Our Case Number: ACP-324383-26

Re: Proposed IDA Belview Infrastructure Development
Belview, Slieverue, County Kilkenny

SID Online Observation

Our observations relate specifically to the section of the application concerning the IDA Kilmurry landbank.

Title: **Proposed Access Road Layout**  
**Sheet 2 of 2**

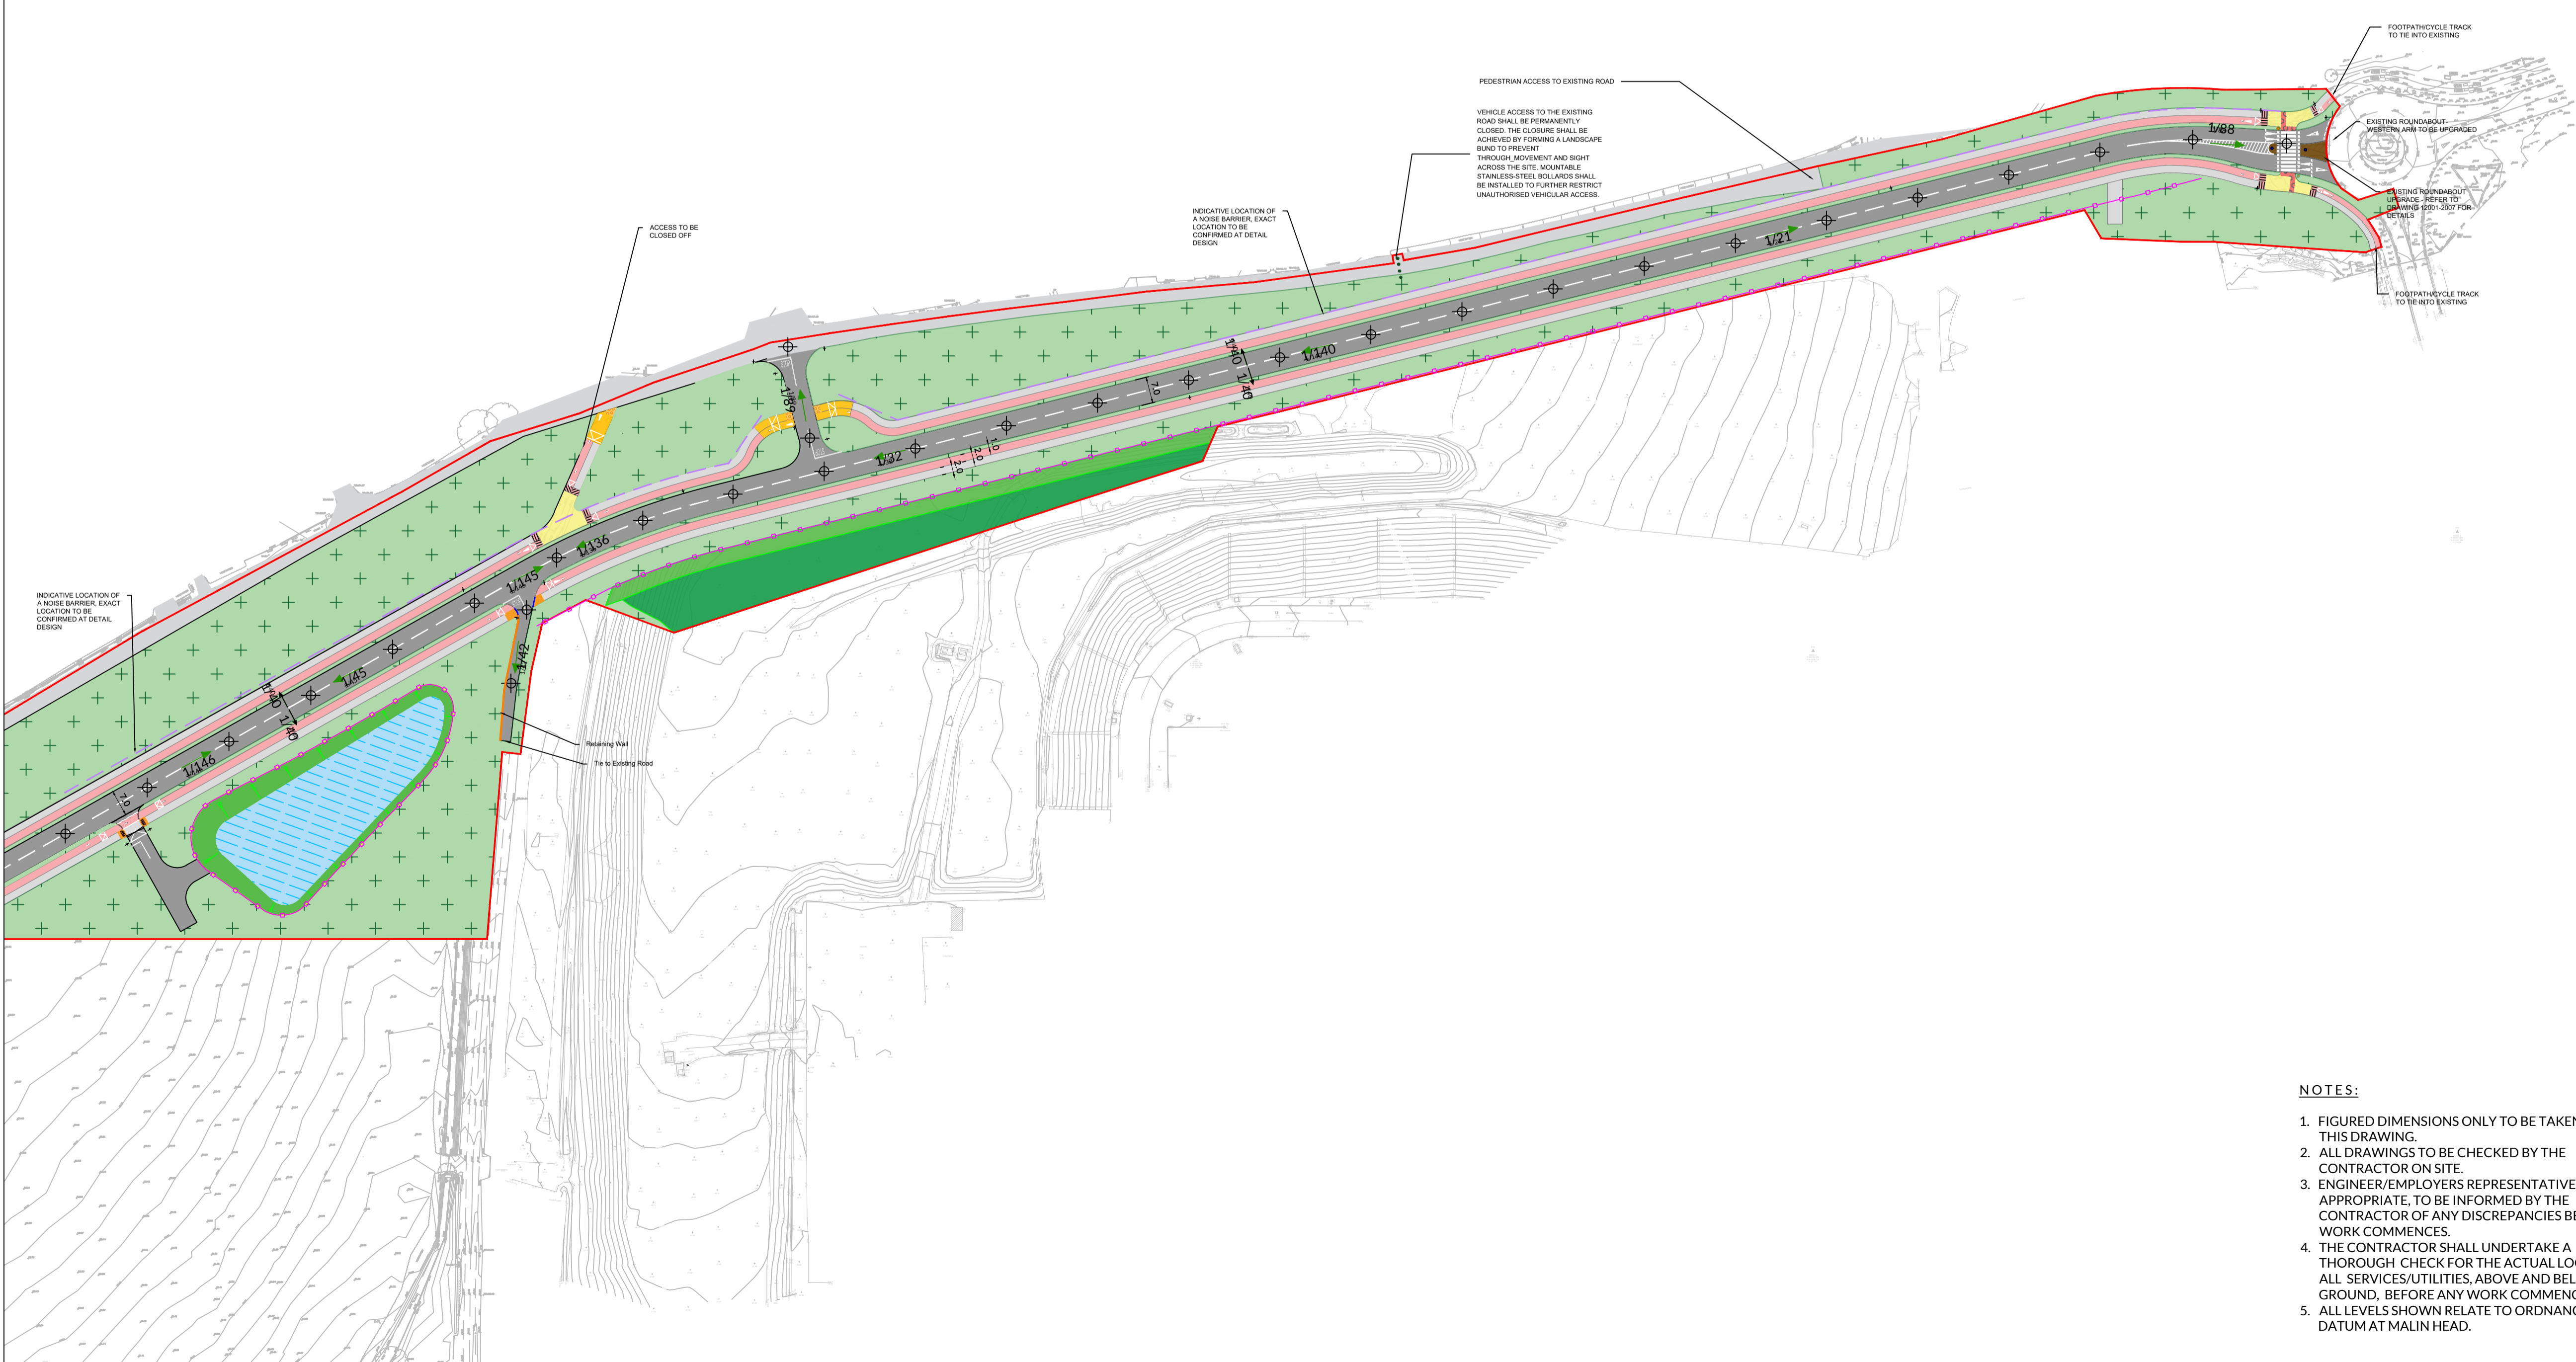
- **Proposed noise barrier mitigation is incomplete and not yet committed to:** Where noise barriers are shown, they appear in short, disconnected sections, marked only as "indicative" and "to be confirmed at detail design." The assessment itself acknowledges that some nearby receptors will remain significantly affected even after the proposed barrier is built, as they fall outside its coverage.

1. That the noise assessment be extended to properly measure and model noise impacts for all residents facing the Kilmurry landbank; and
2. That a 2-metre high earthen mound be constructed, extending from the new roundabout as far west as possible, as a firm (not indicative) mitigation commitment. An earthen mound would provide effective long-term noise attenuation, a better visual/landscape outcome than a standard barrier, and will be well-matured by the design year (2040). This is a durable, cost-effective solution.
